Hu Yu Residence

Addition and Remodel

SHEET NUMBER:
A1.01

Summary of Comments on 2201-224-SUB1-PLANS_review.pdf

**Building Section A-A**  
Scale: 1/4" = 1'-0"

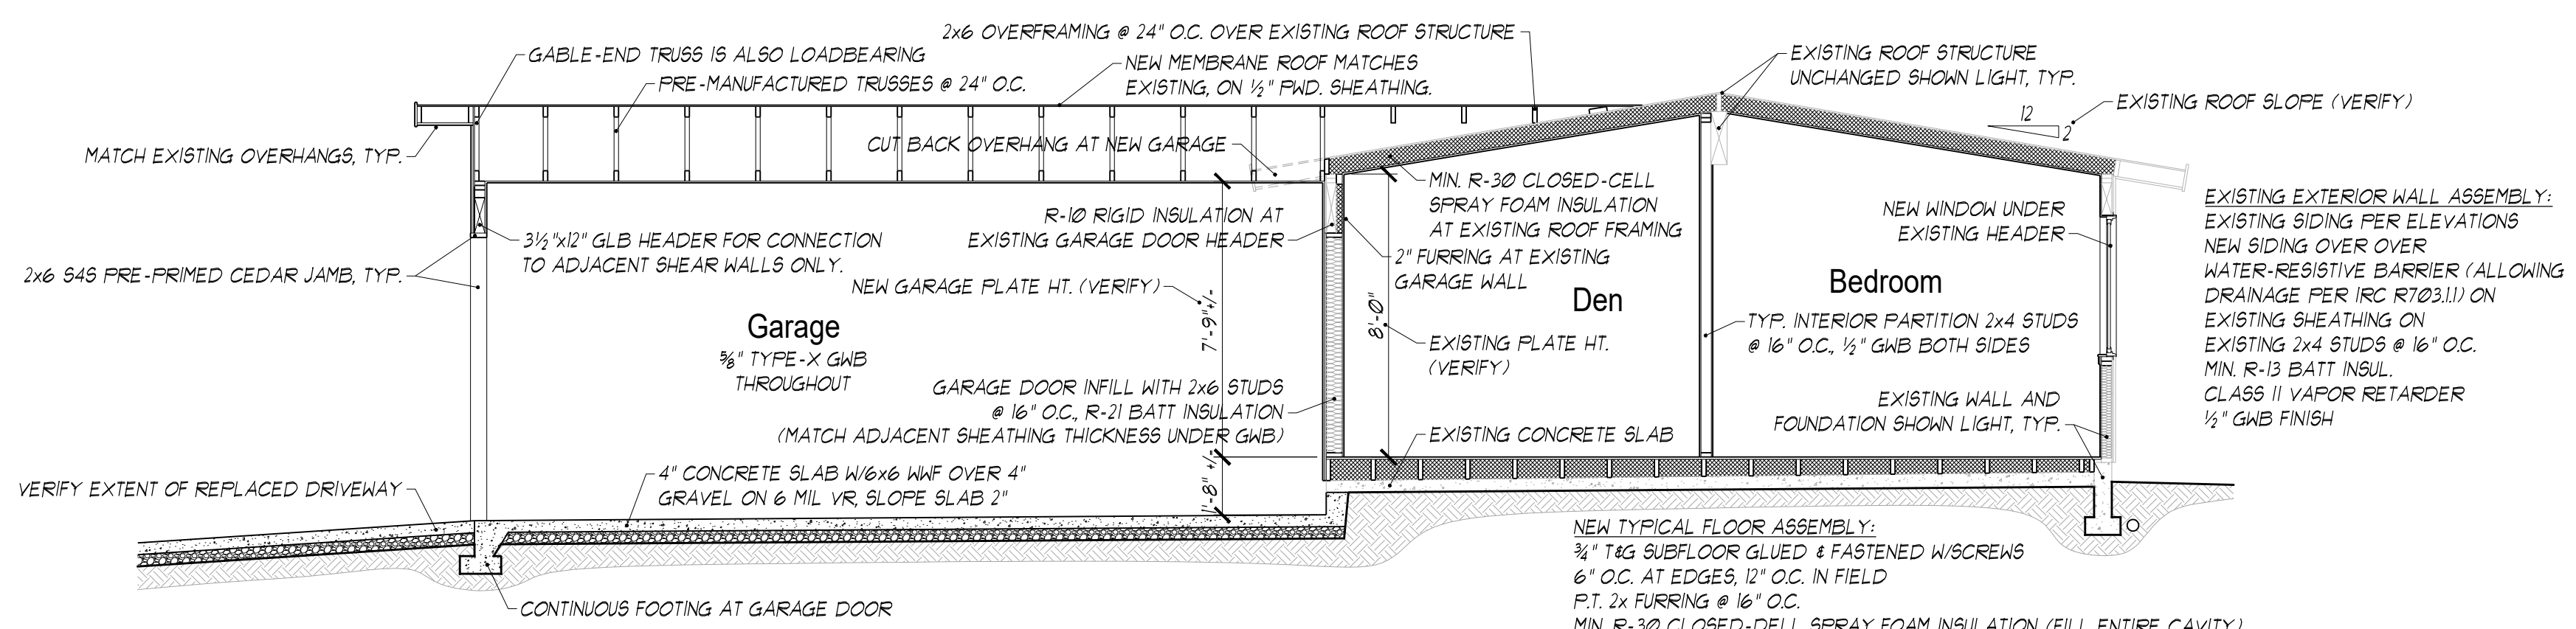
<p>Number: 1</p>	<p>Author: Building Plan Review (jacob.halverson@mercerisland.gov)</p>	<p>Subject: Sticky Note</p>	<p>Date: 6/22/2022 10:11:47</p>
<p> Provide foundation plan and locate all new and existing (presumed) extents/depths and foundations.</p>			
 <p>Number: 2</p>	<p>Author: Building Plan Review (jacob.halverson@mercerisland.gov)</p>	<p>Subject: Sticky Note</p>	<p>Date: 6/22/2022 10:07:18</p>
<p> Room as detailed (Den) resembles a sleeping room, provide this window as egress.</p>			
 <p>Number: 3</p>	<p>Author: Building Plan Review (jacob.halverson@mercerisland.gov)</p>	<p>Subject: Sticky Note</p>	<p>Date: 6/22/2022 10:06:36</p>
<p> Provide an additional smoke detector in this room.</p>			
 <p>Number: 4</p>	<p>Author: Building Plan Review (jacob.halverson@mercerisland.gov)</p>	<p>Subject: Sticky Note</p>	<p>Date: 6/22/2022 10:05:29</p>
<p> Provide note that provides compliance per: R302.5: Openings and penetrations through the walls or ceilings separating the dwelling from the garage shall be in accordance with Sections R302.5.1 through R302.5.3.</p>

<p>Number: 5</p>	<p>Author: Building Plan Review (jacob.halverson@mercerisland.gov)</p>	<p>Subject: Sticky Note</p>	<p>Date: 6/22/2022 10:03:39</p>
<p> Provide all separation requirements per IRC R302.6 on plan or building section for clarity for dwelling/garage fire separation. Garage separation requirements include 5/8" type X between garage and habitable space above, 1/2" between garage and habitable space on garage side of walls, and a 20 min rated or solid core entry door with a self-closing device.</p>			
 <p>Number: 6</p>	<p>Author: Building Plan Review (jacob.halverson@mercerisland.gov)</p>	<p>Subject: Sticky Note</p>	<p>Date: 6/22/2022 10:04:29</p>
<p> dedicated mechanical space found elsewhere in the residence. Please locate major mechanical equipment.</p> <p>If Mechanical equipment appears to interfere with drive aisle and If mechanical equipment is to be in garage, show location and provide bollard/bollards or approved alternative to protect mechanical equipment in driveway per M1307.3.1. If curb provided note requirement per M1307.3 requiring 18".</p>

<p>Number: 7</p>	<p>Author: Building Plan Review (jacob.halverson@mercerisland.gov)</p>	<p>Subject: Sticky Note</p>	<p>Date: 6/22/2022 10:09:07</p>
<p> Provide attic ventilation per (R806.1) & calculations unless insulation is applied on the under-side of roof sheathing. (R806.5)</p>			
 <p>Number: 8</p>	<p>Author: Building Plan Review (jacob.halverson@mercerisland.gov)</p>	<p>Subject: Sticky Note</p>	<p>Date: 6/22/2022 10:03:02</p>
<p> Provide heat detector. R314.2.3 A heat detector or heat alarm rated for the ambient outdoor temperatures and humidity shall be installed in new garages that are attached to or located under new and existing dwellings. Heat detectors and heat alarms shall be installed in a central location and in accordance with the manufacturer's instructions.</p>			
 <p>Number: 9</p>	<p>Author: Building Plan Review (jacob.halverson@mercerisland.gov)</p>	<p>Subject: Sticky Note</p>	<p>Date: 6/22/2022 10:17:39</p>

<p> Indicate any shearwalls, provide shearwall design and schedule to resist any lateral forces garage is subject to. Provide holddown details, locations, and design if required - on foundation or framing plan.</p>			
 <p>Number: 10</p>	<p>Author: Building Plan Review (jacob.halverson@mercerisland.gov)</p>	<p>Subject: Sticky Note</p>	<p>Date: 6/22/2022 10:16:29</p>
<p> Provide a typical over framing detail of connection between existing sheathing/roof system and new proposed roof sheathing and system. Specify nailing at a minimum at connections.</p>			
 <p>Number: 11</p>	<p>Author: Building Plan Review (jacob.halverson@mercerisland.gov)</p>	<p>Subject: Sticky Note</p>	<p>Date: 6/22/2022 10:19:49</p>
<p> Provide truss to top plate detail structural detail.</p>			
 <p>Number: 12</p>	<p>Author: Building Plan Review (jacob.halverson@mercerisland.gov)</p>	<p>Subject: Sticky Note</p>	<p>Date: 6/22/2022 10:26:55</p>

<p> R301.1.3: Work done in this area affects structural. Specification and details of a new header and supports traced to foundation/ shear transfer will be required with supporting calculations. Prescriptive approach to design if conforming entirely to WSRC, and calculations for any elements which are designed per WSBC to be provided.</p> <p>If this is not done prescriptively a registered design professional will need to do design and submit calculations with a key plan.</p>			
 <p>Number: 13</p>	<p>Author: Building Plan Review (jacob.halverson@mercerisland.gov)</p>	<p>Subject: Sticky Note</p>	<p>Date: 6/22/2022 10:23:03</p>
<p> Provide this structural detail, at proposed new flooring to existing foundation to floor. I.e. Is this is ledger condition now?</p>

SHEET TITLE:  
**Exterior Elevations  
Details**

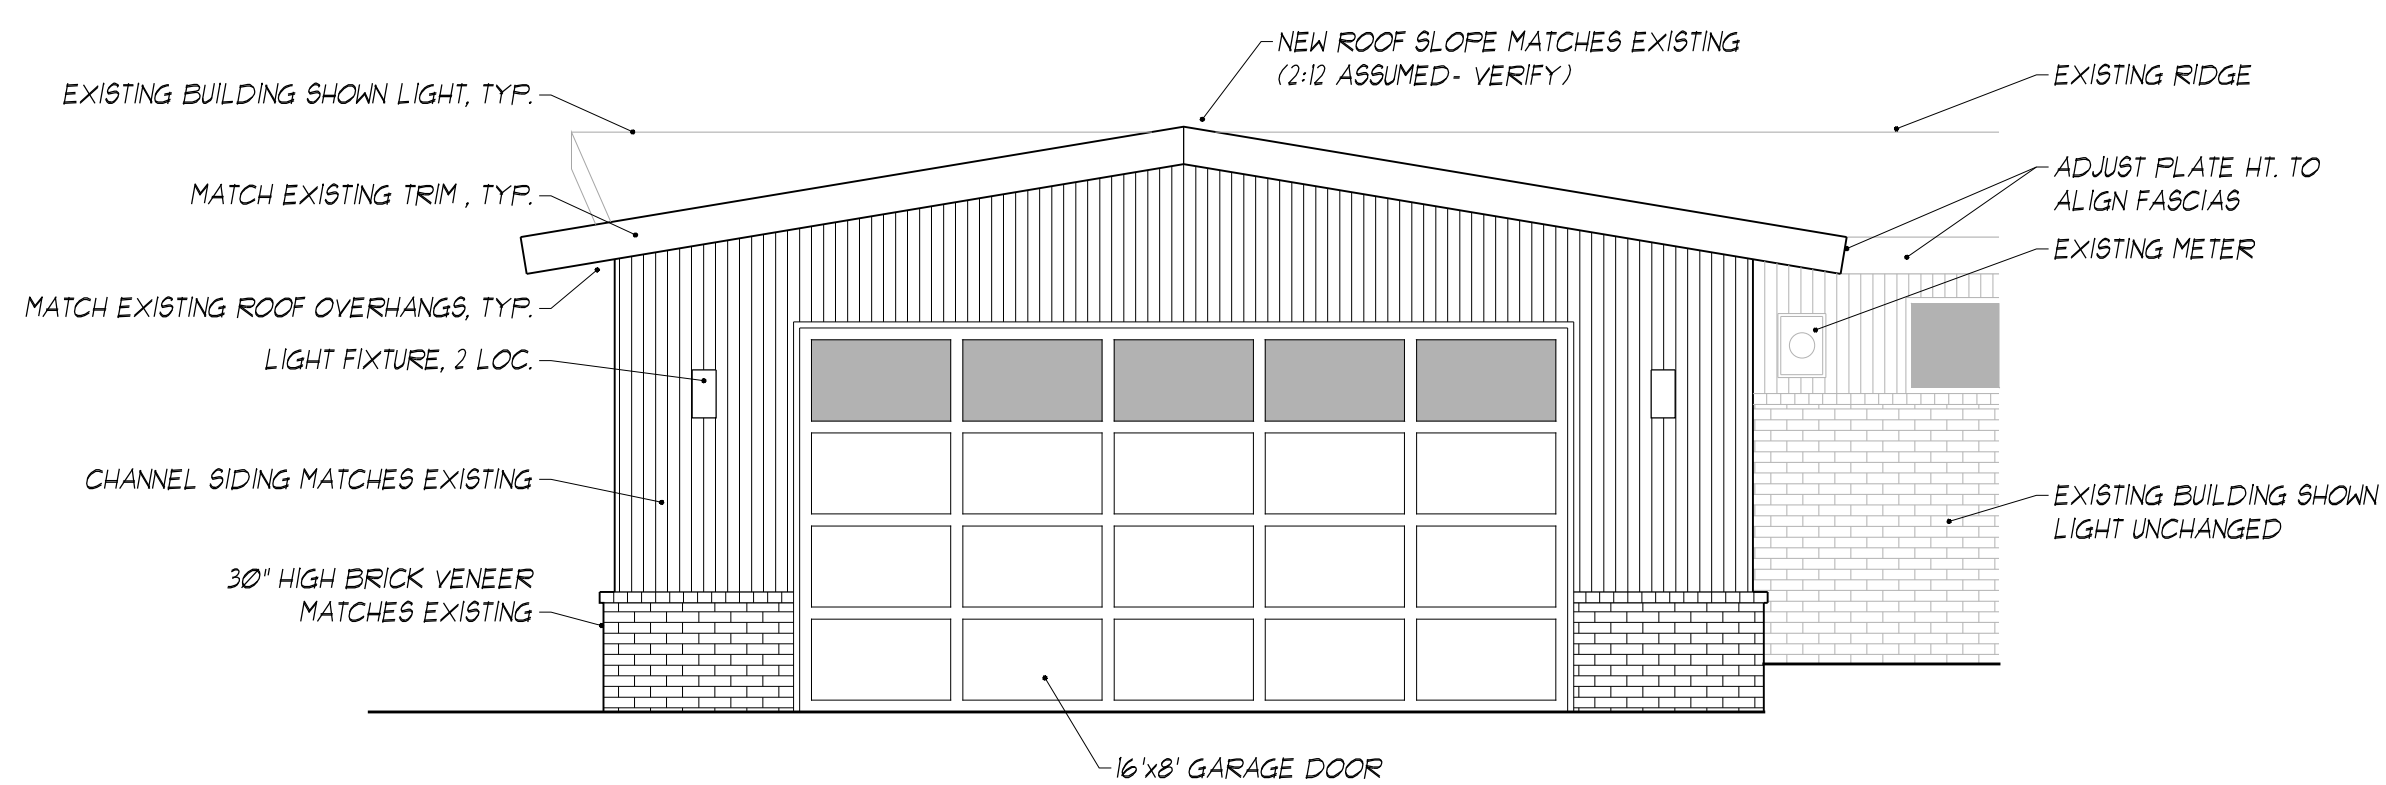
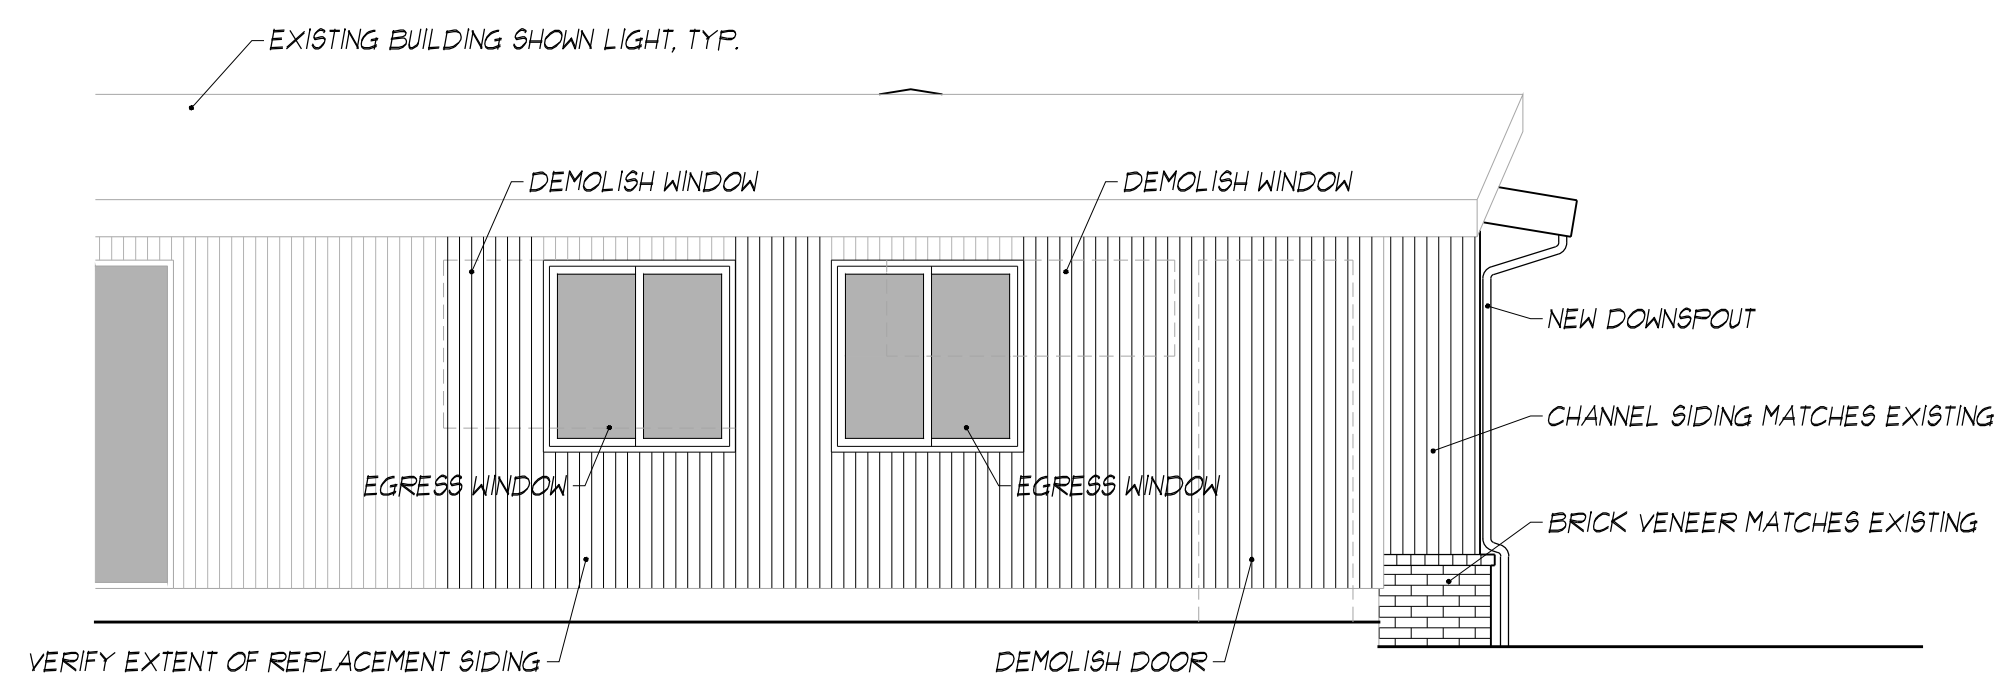
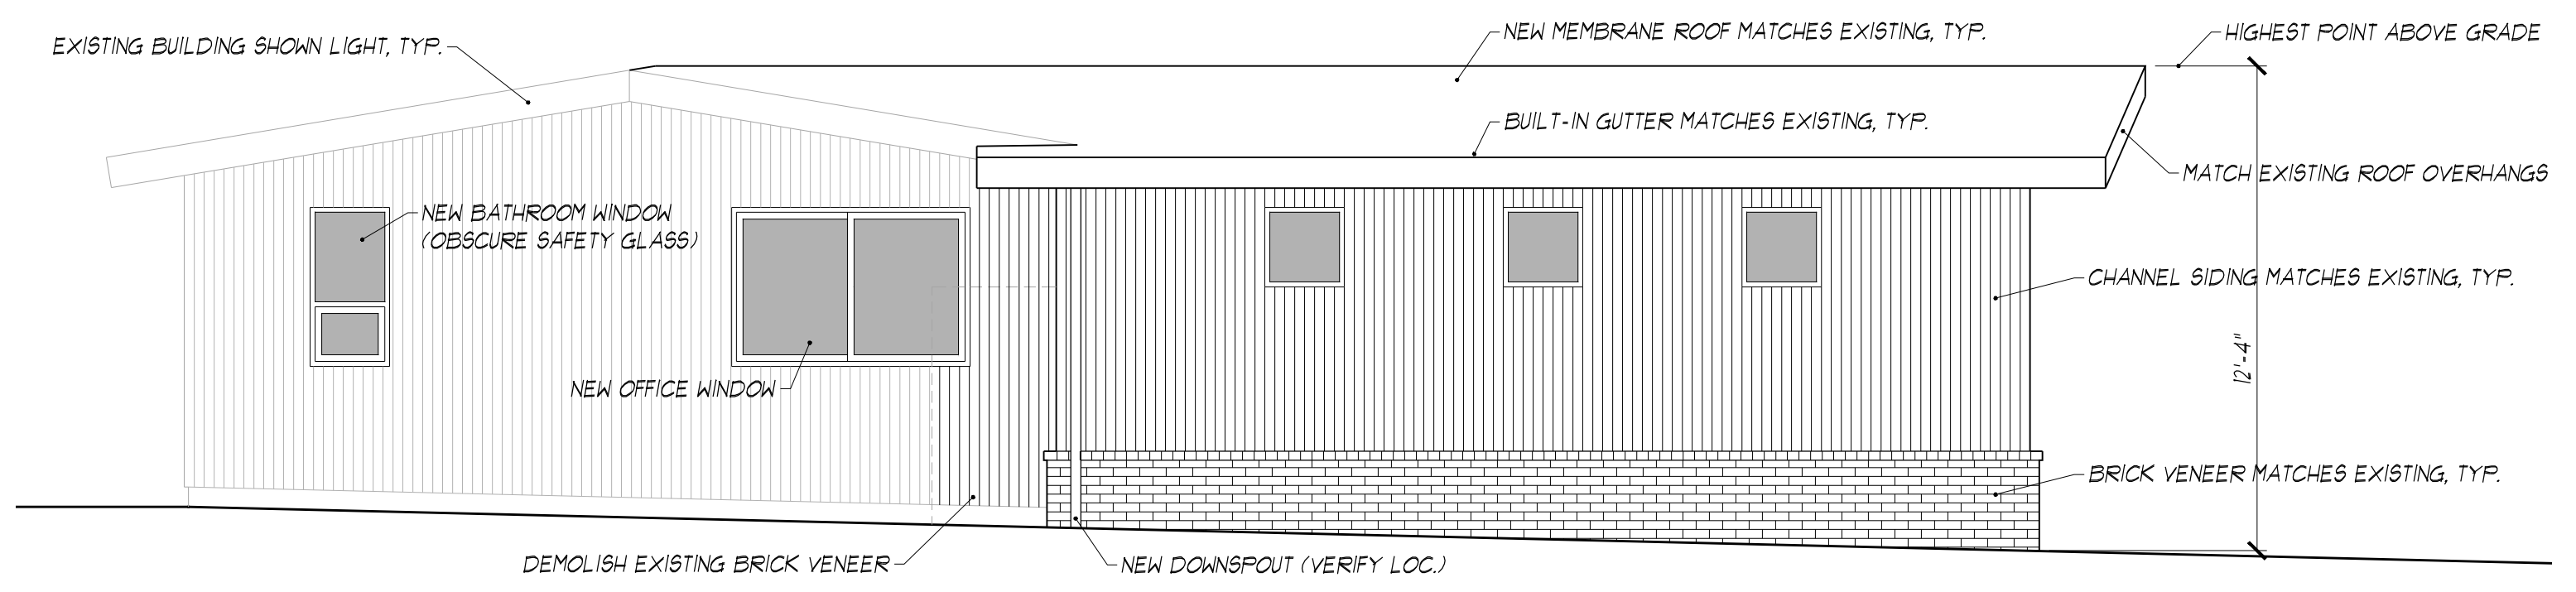
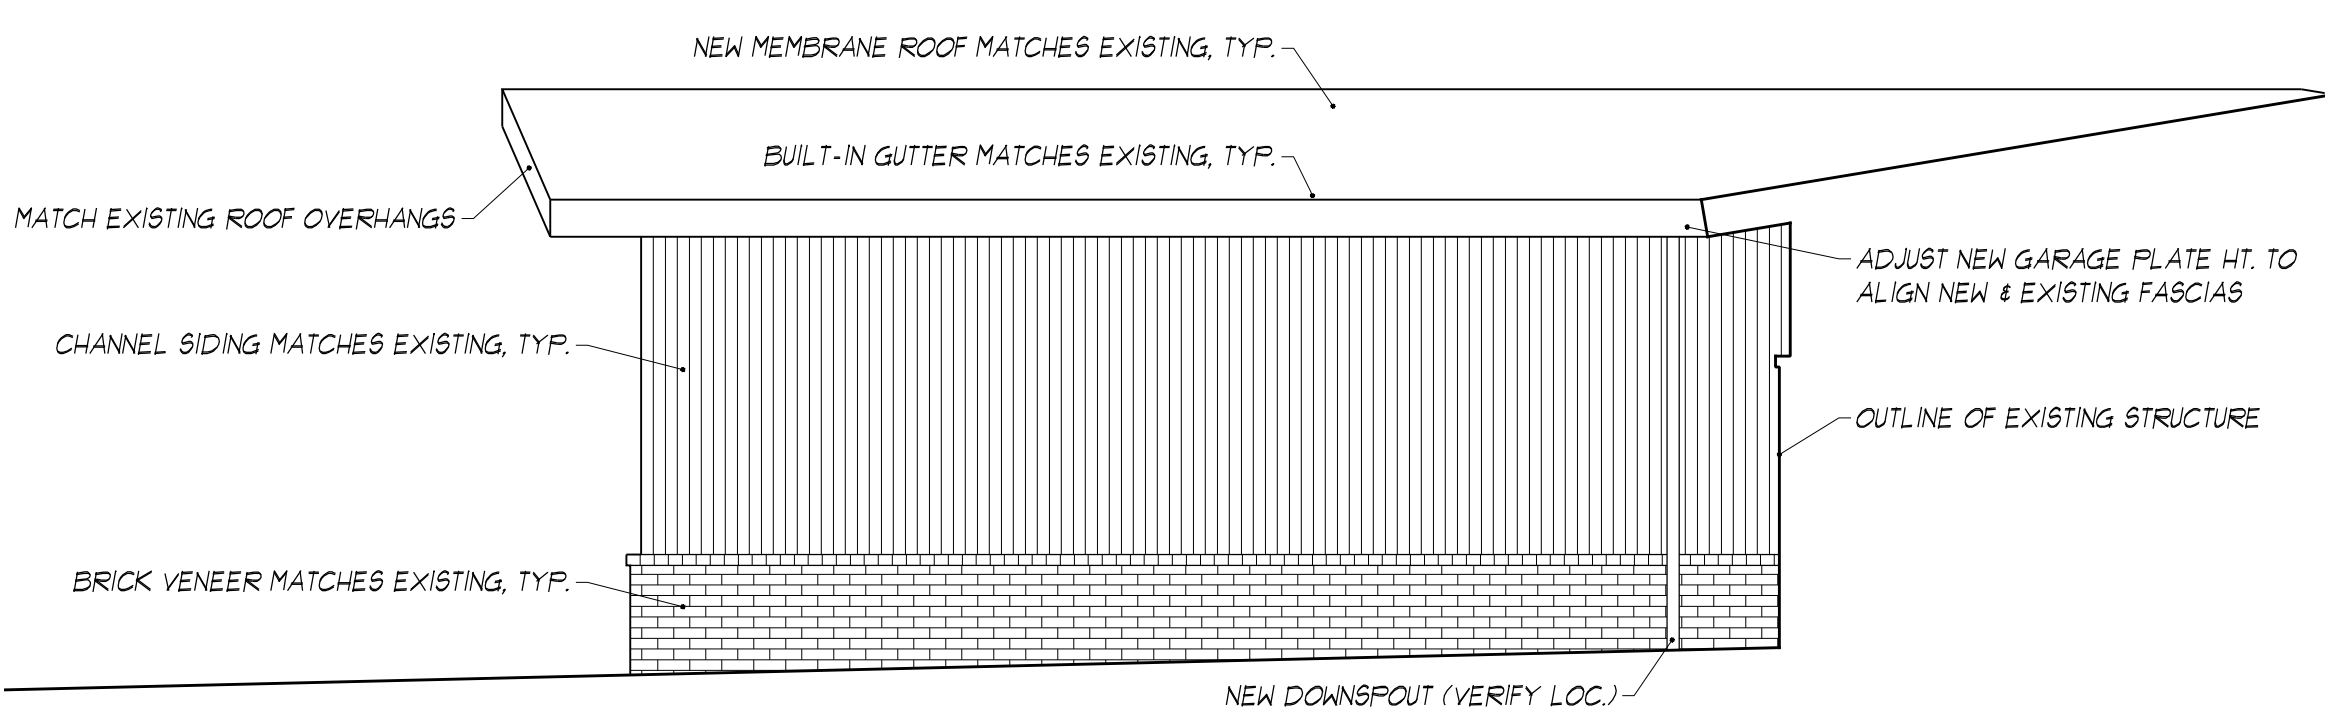
Number: 1 Author: Land Use Planning Review (molly.mcguire@mercerisland.gov) Subject: Sticky Note Date: 6/6/2022
3:00:24 PM
Provide ABE calculations

Number: 2 Author: Land Use Planning Review (molly.mcguire@mercerisland.gov) Subject: Sticky Note Date: 6/6/2022
3:00:10 PM
Provide existing and finished grades, Average Building Elevation, and ABE +30 on all elevation plans.
